10 August 2017

**RE: Application to modify existing project approval MP 08_0157 (MOD 4)
Joe White Maltings, Stonny Batter Road, Minto**

Andrew MacGee
Acting Manager Development Services

Figure 3 Inbound Operational Truck Route from the South

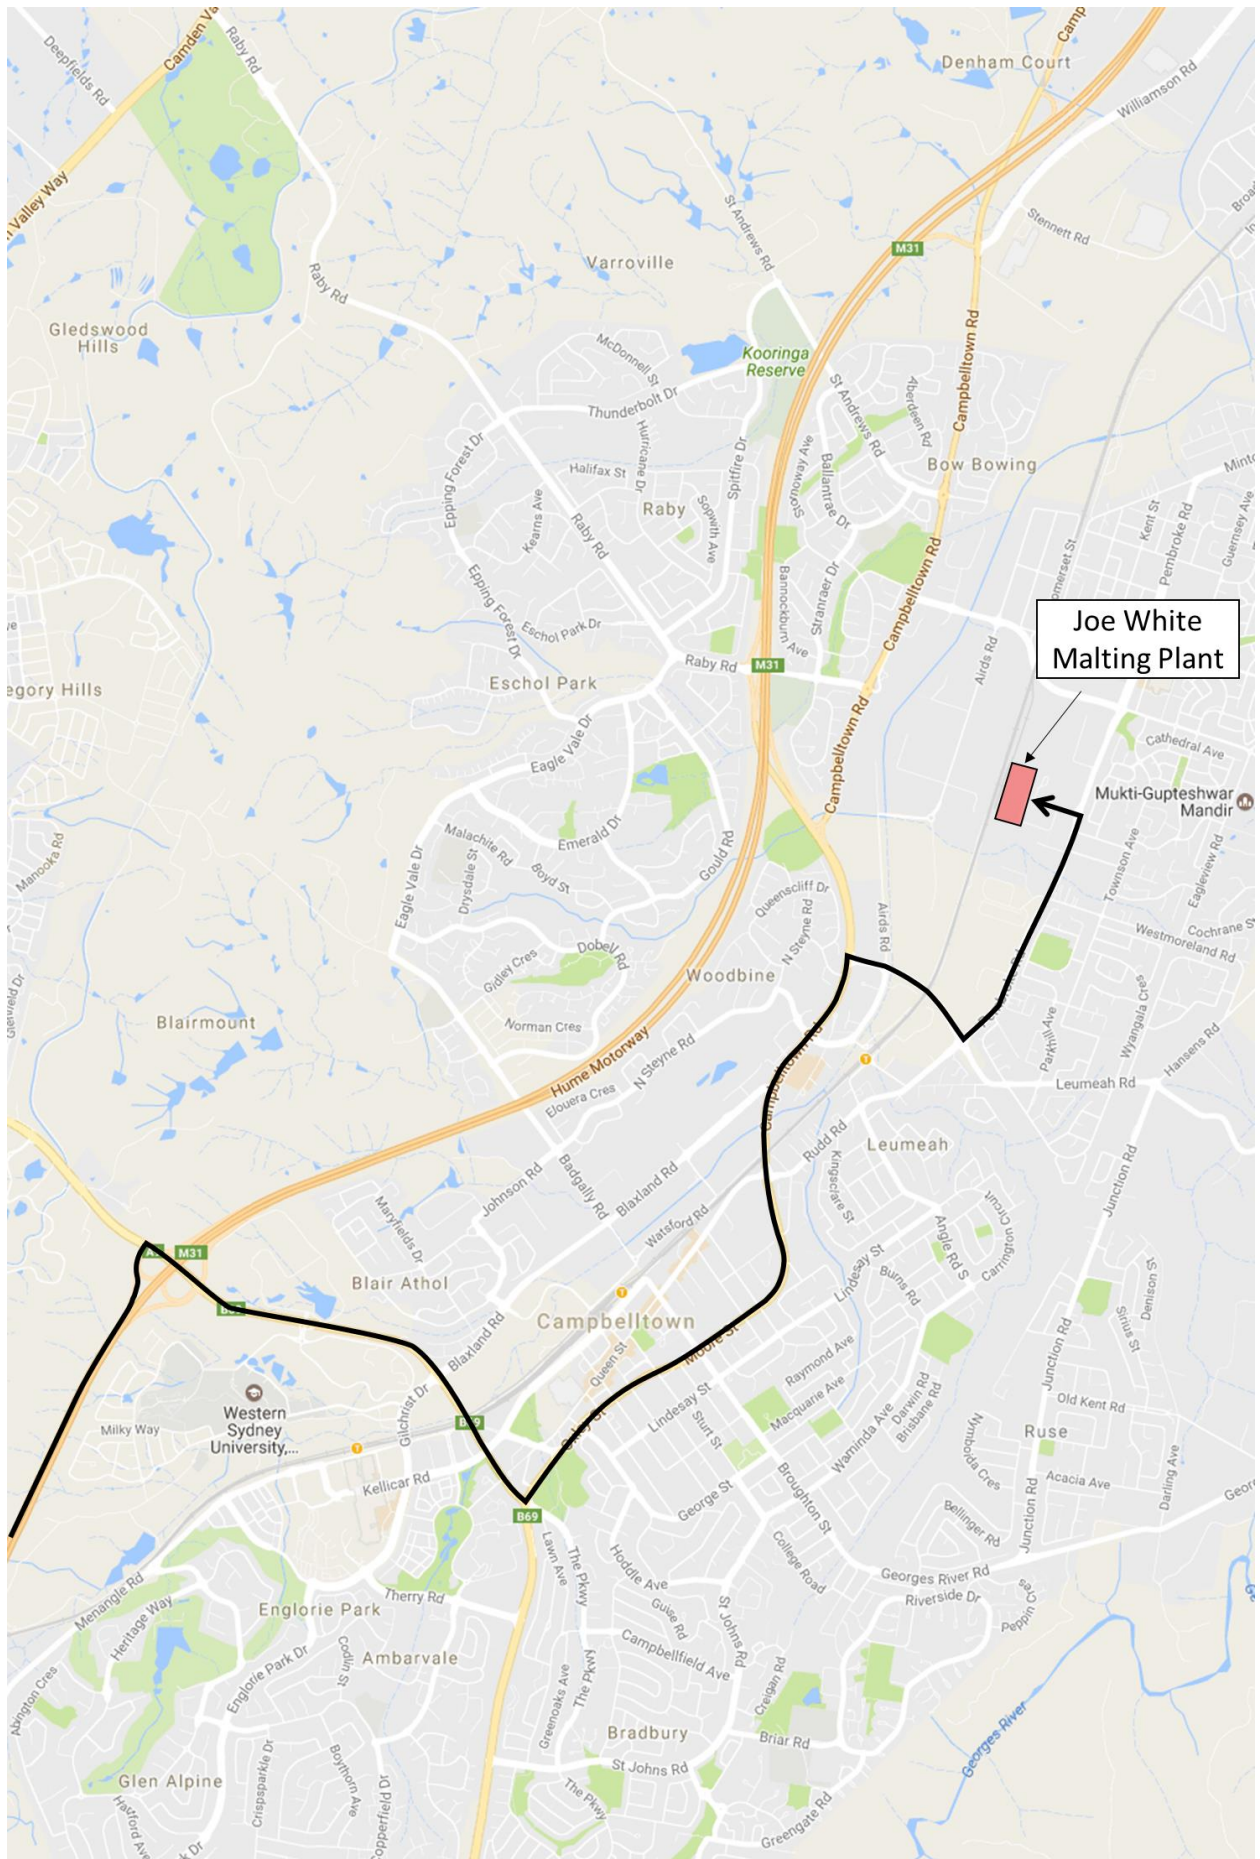
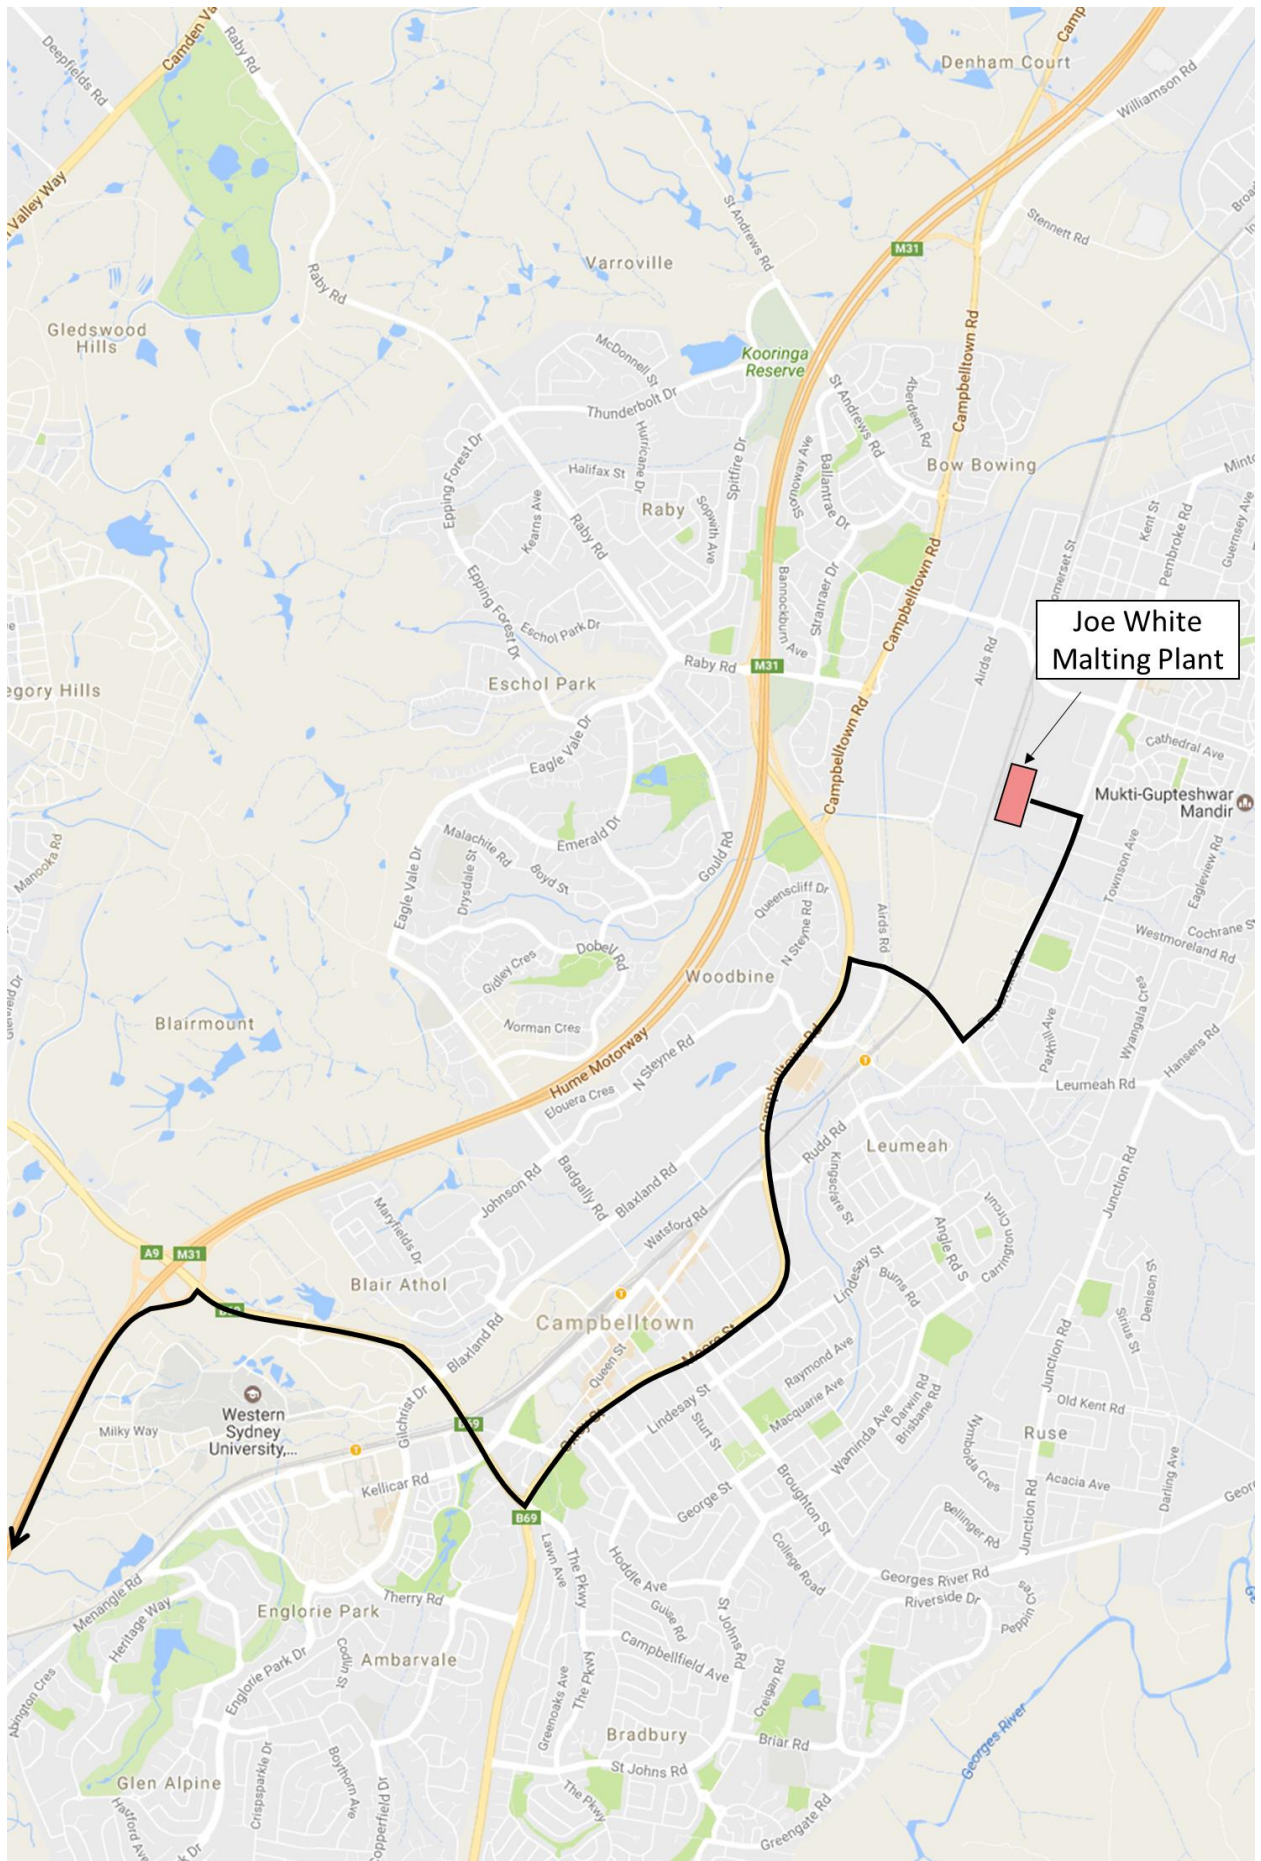
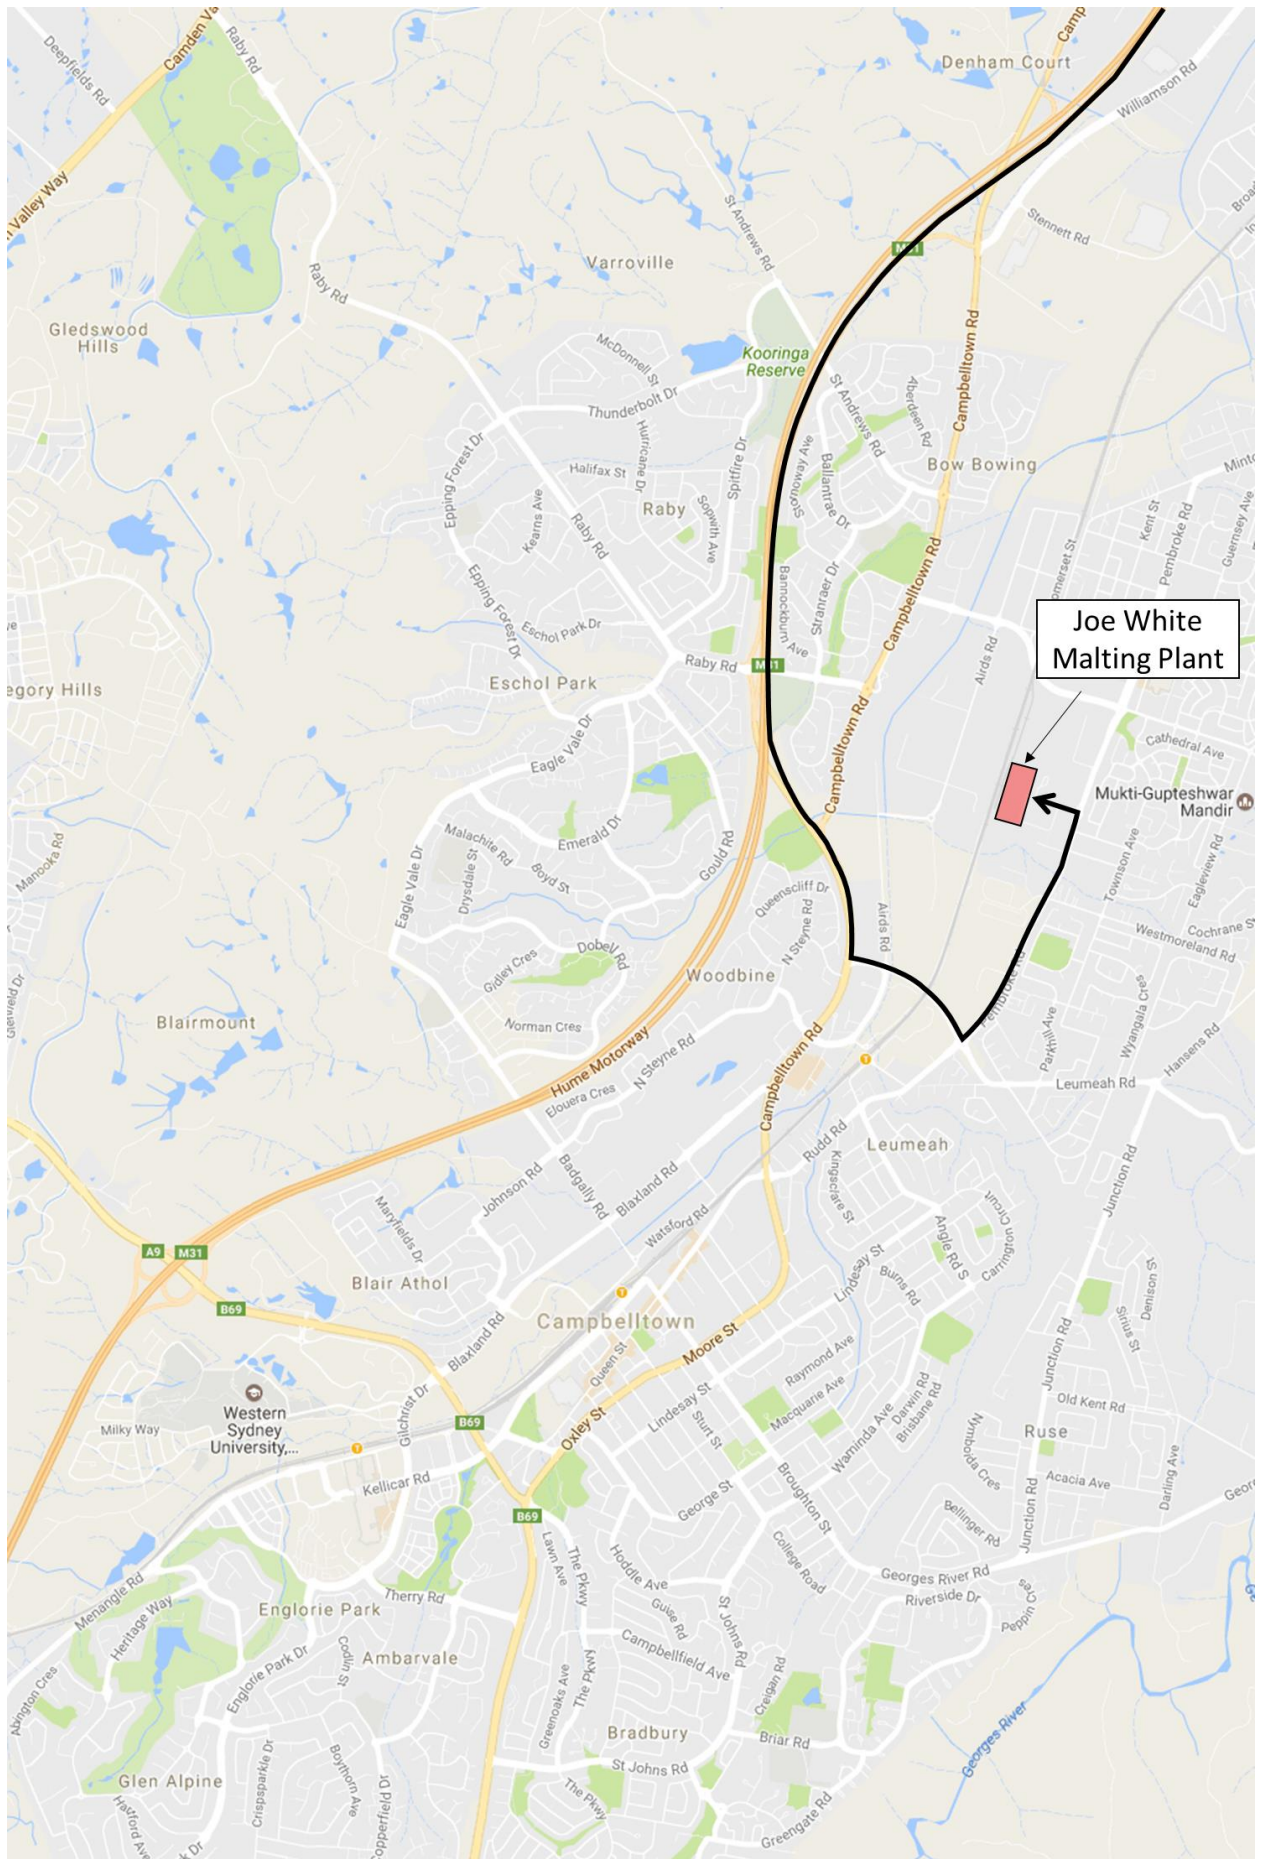
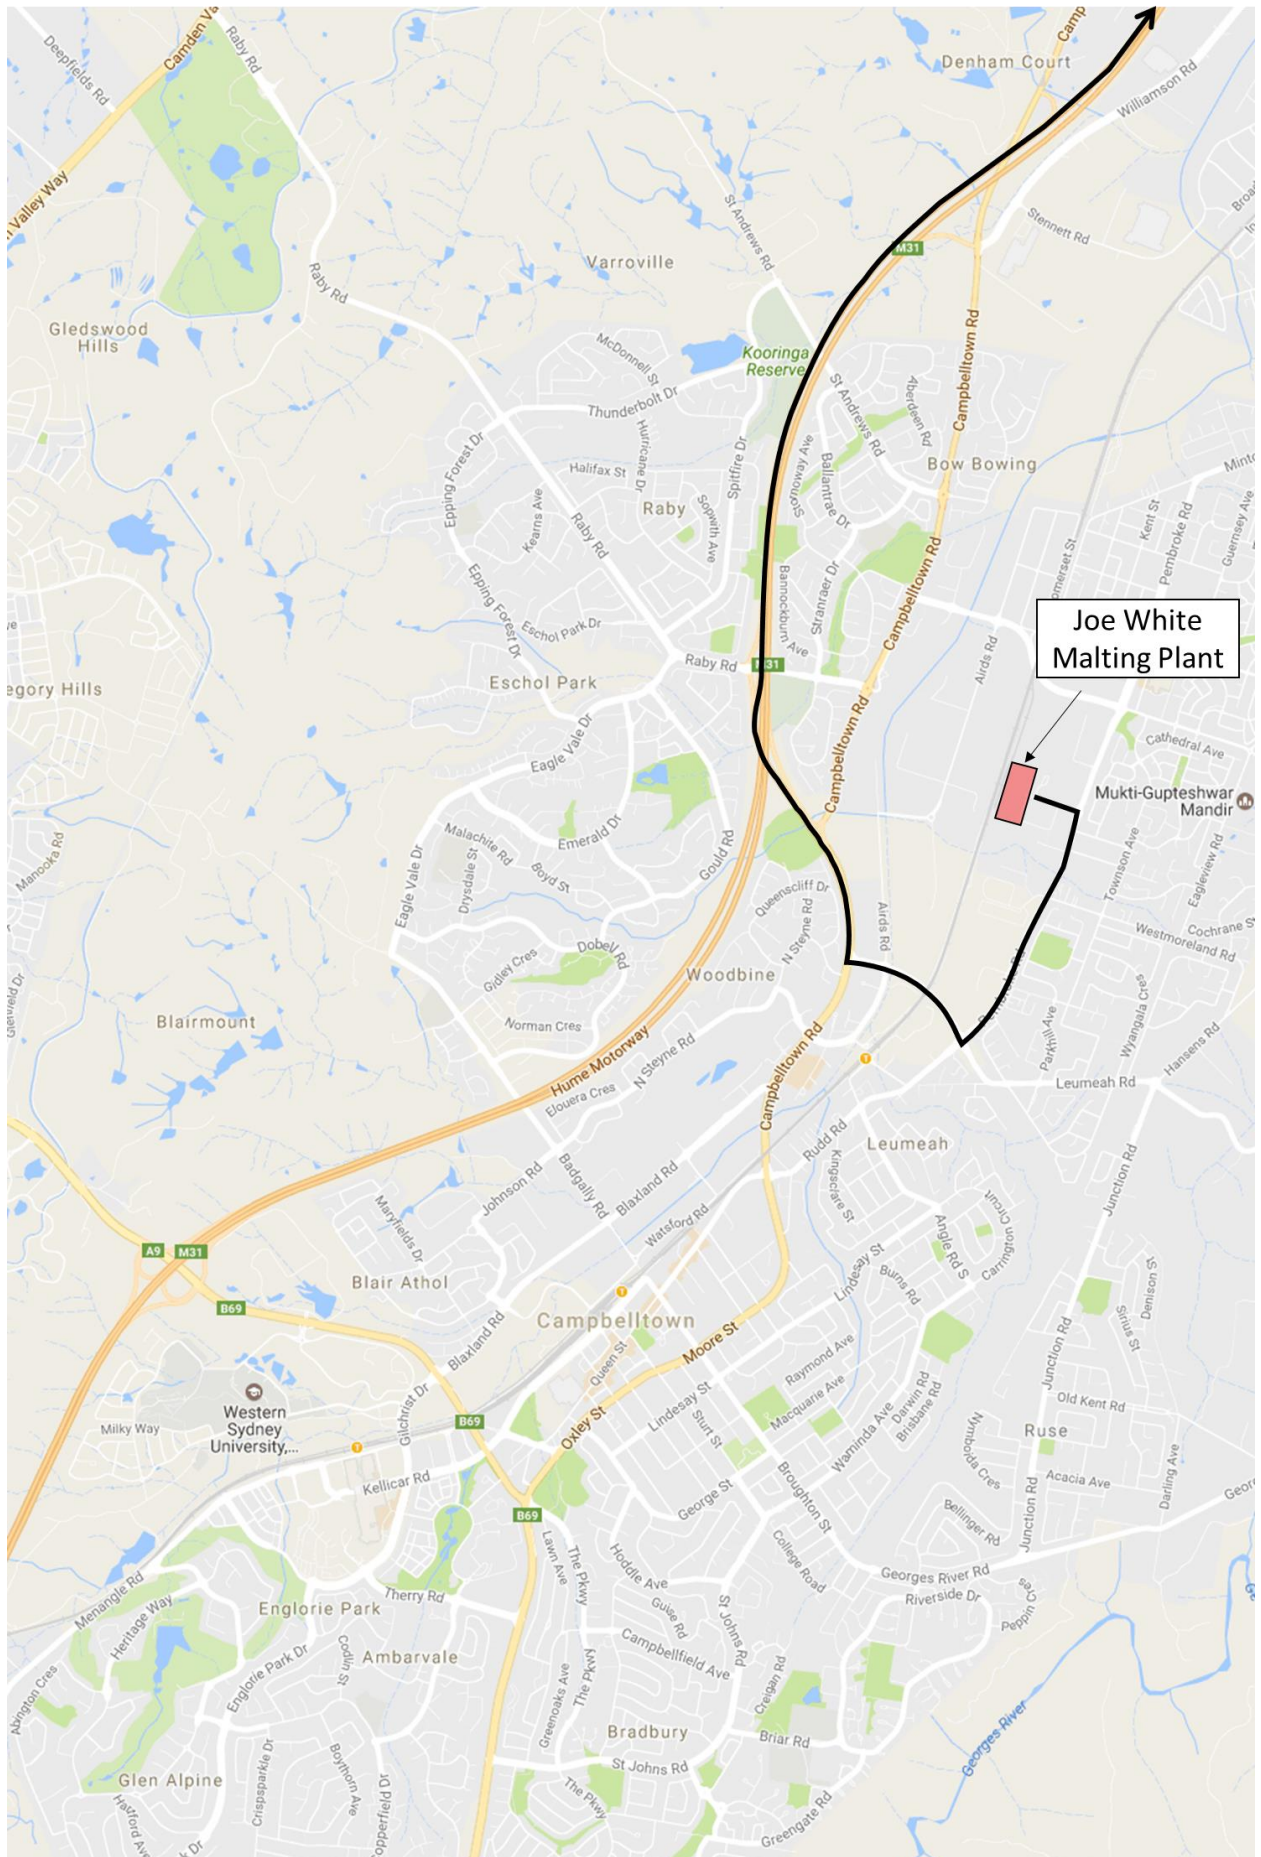
- A condition requiring that road traffic associated with the development travel on the nominated routes within Cardno's 'Response to RMS and Campbelltown Council comments' dated 1 May 2017, specifically pages 13, 14 and 15.
